From: Polly Harris-Gorf
Sent: 13 April 2022 08:56
To: _planningadvice
Subject: FW: 21-L74 - PLOT 9 HOLBEACH - REF: H09-0253-22
Attachments: We sent you safe versions of your files; 21-L74-C201 - AJS - PROPOSED ROOF PLAN AND SECTIONS.pdf

BUILDING SECTION A-A
SCALE: 1:100

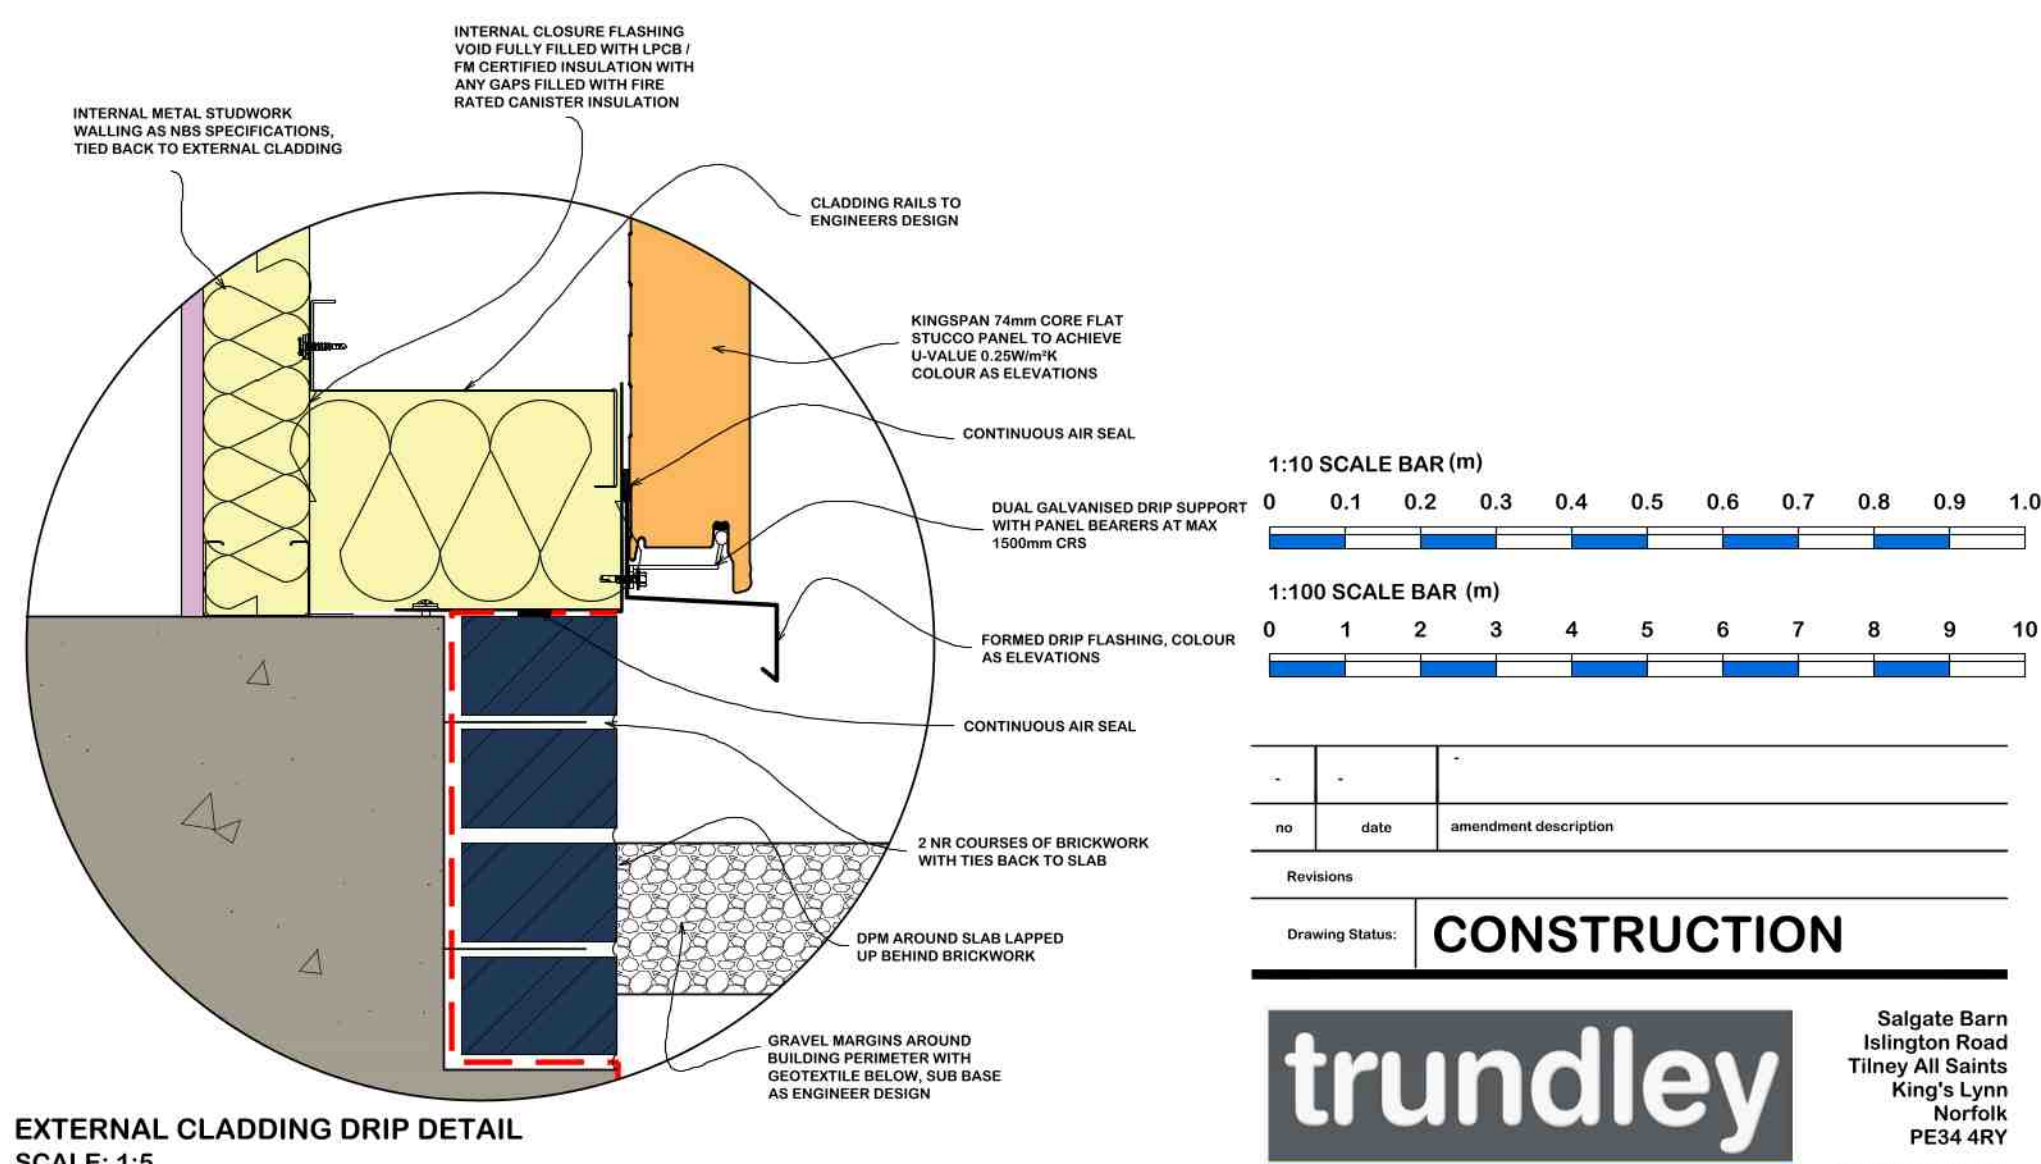
Further to your submission below, please can you address the concerns of the SHDC Environmental Protection Officer and the Internal Drainage Board, that can be viewed on line at this link.

Site specific section drawing attached which are to be utilised across the development building as requested, the project specifications have detailed the requirement for Radon barrier throughout the Ground floor slab.
